**RE: WSU MILPERRA – 2 AND 2A BULLECOURT AVENUE, MILPERRA (SSD-97092958)
TRAFFIC RESPONSE TO DPHI COMMENTS**

This letter provides a response to the comments provided by the Development Assessment and Sustainability of Department of Planning, Housing and Infrastructure (DPHI) in its email dated 22 April 2026.

Project Ref	Stage No	Drawing No	Rev
2301879	321	302	C

Project Ref	Stage No	Drawing No	Rev
2301879	321	302	C

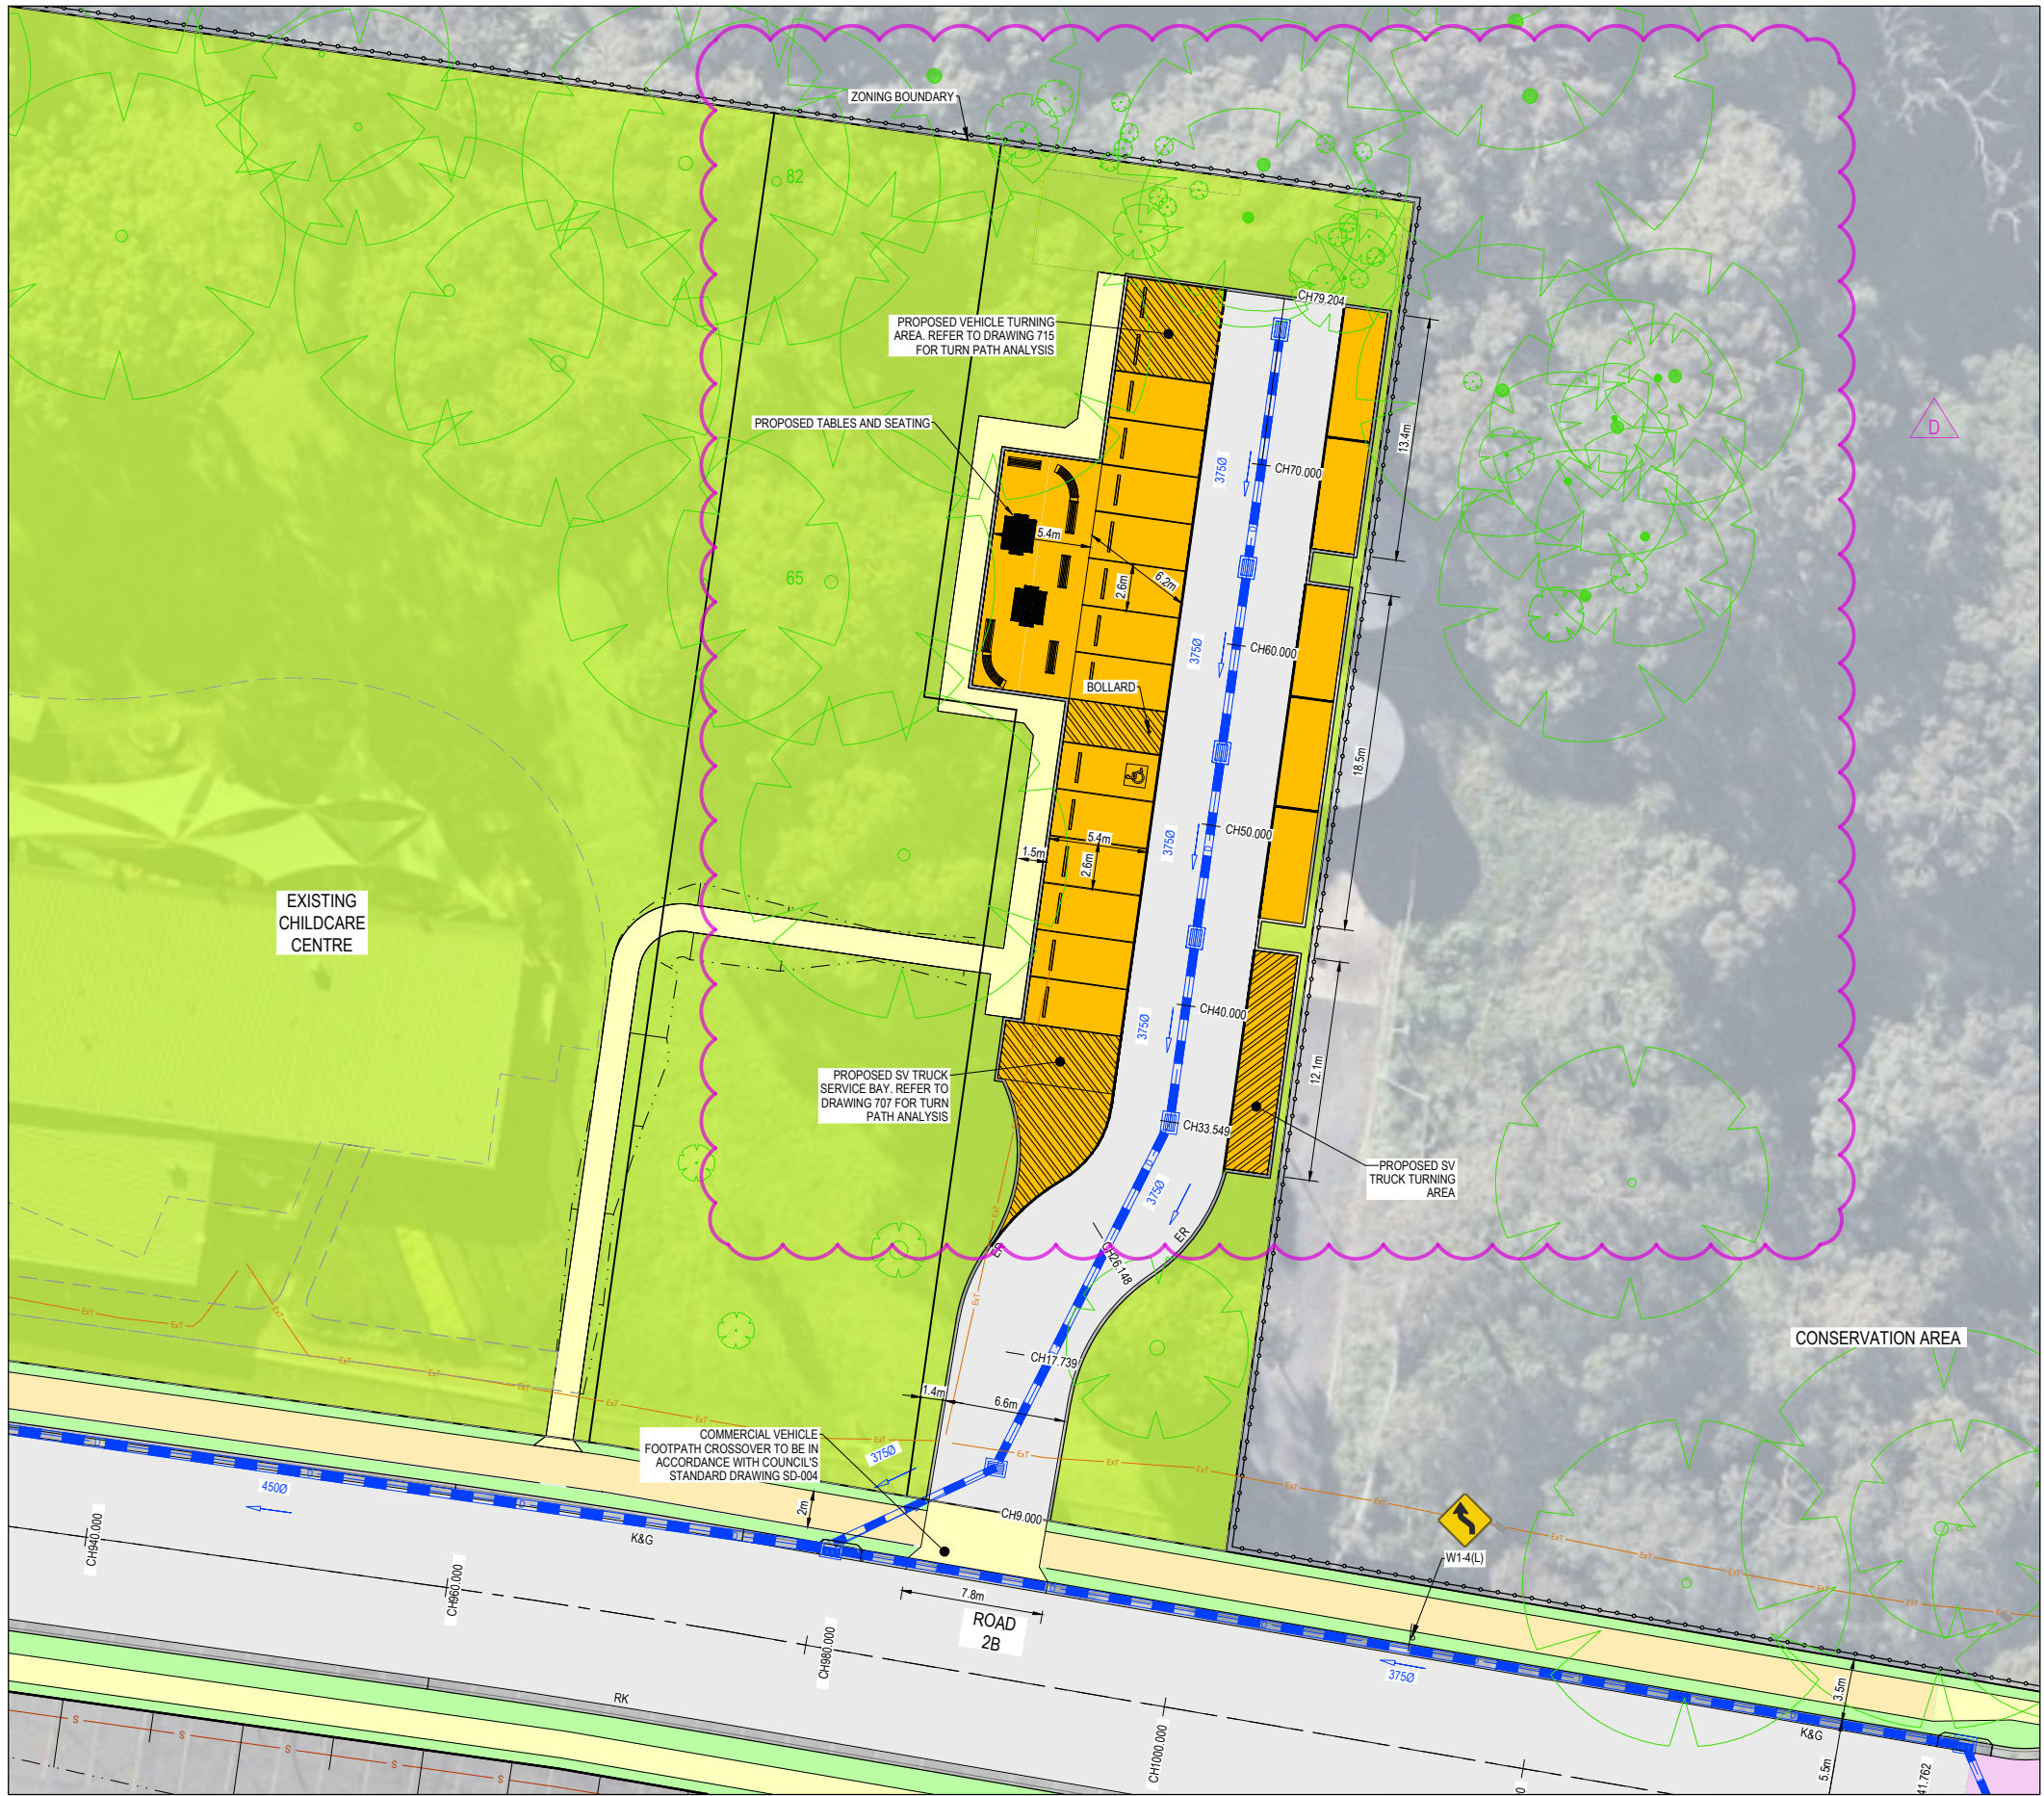
DPHI's Comments	TTPP Response
	A.2 Design and check vehicles  Figure A.2 – Check vehicles should be allowed to cross the centre of a carriageway when turning on local streets where no centreline is marked (Source: NACTO, Urban Street Design Guide)
Horsley Road Intersection - Retention of the existing road alignment and roundabout, with amendments to the footpath location to reduce impacts on the C2 zoned land is noted. - This design requires the introduction of multiple turning restrictions, including limiting access to the opposite property, and forces pedestrians to deviate from their natural desire lines. While individual design elements may technically comply with relevant standards, the scheme does not deliver a coherent and effective overall design outcome. - Additional details, or modification of the design to ensure the arrangement results in a safe and effective outcome for vehicles and pedestrians is required.	Regarding the impact on access to the opposite property, it is assumed that the comment refers to the opposite property on Horsley Road (i.e. #270 Horsley Road). It should be noted that the existing driveway on the eastern side of the roundabout will be removed under the development approval (SSD-51147710) of the opposite property. Therefore, the proposed Horsely Road access intersection design has no impact on the access of surrounding properties. In terms of the pedestrian access along the northern side of the exit roadway of Road 2B, it is noted that the northern verge area adjacent to the exit roadway is located within the C2 Environmental Conservation zone, and therefore any works must seek to minimise disturbance to the area. As a result, a paved pedestrian footpath is not permitted within the C2 zone. The original SSDA civil plans propose a footpath on the centre island on Road 2B at the intersection, connecting the footpath on the northern side of Road 2B and the existing footpath on the western side of Horsley Road. However, pedestrians would need to cross Road 2B twice when walking between the site and Horsley Road north of the roundabout.

DPHI's Comments	TTPP Response
	Alternatively, a raised boardwalk is proposed within the area connecting the footpath on the northern side of the new access road to the existing footpath on the western side of Horsley Road, as shown in the figure below. The boardwalk will facilitate a controlled and desired pedestrian connection between the development frontage and the surrounding pedestrian facilities. Signage can be provided on the footpath on Horsley Road before crossing the exit roadway, to guide pedestrians to walk through the boardwalk and cross at the pram ramp on Road 2B. The boardwalk will comprise a raised pathway structure designed to traverse the conservation area while minimising impacts to existing vegetation, ground conditions, and ecological values. The raised design also reduces the need for bulk earthworks and allows natural drainage patterns and ground-level habitats to be preserved. The design will consider tree root mapping undertaken within the corridor, with particular consideration given to the structural root zones (SRZ) of adjacent trees. The alignment and support locations of the boardwalk will be developed to ensure that any structural encroachments are avoided or minimised, with all primary footings positioned outside defined tree structural roots where practicable.

DPHI's Comments	TTPP Response
	From an engineering standpoint, the structure will be designed to ensure durability, constructability, and minimal maintenance, with appropriate consideration given to footing solutions and selected materials to suit the C2 Environmental Conservation zone. Overall, the proposed boardwalk serves as a key mitigation measure in addressing the pedestrian connectivity, by encouraging pedestrian movement along a defined and safer route separated from vehicular traffic, while avoid deviating pedestrian from their natural desire lines. Notwithstanding that above, an independent risk assessment has been undertaken by PDC Consultants assessing the differences between the two Horsley Road intersection designs. It is concluded in the risk assessment report that the updated design with the boardwalk provides an improved outcome for pedestrians, by minimising the number of conflict points when walking north-south on Horsley Road. The risk assessment report is provided in Attachment Two.
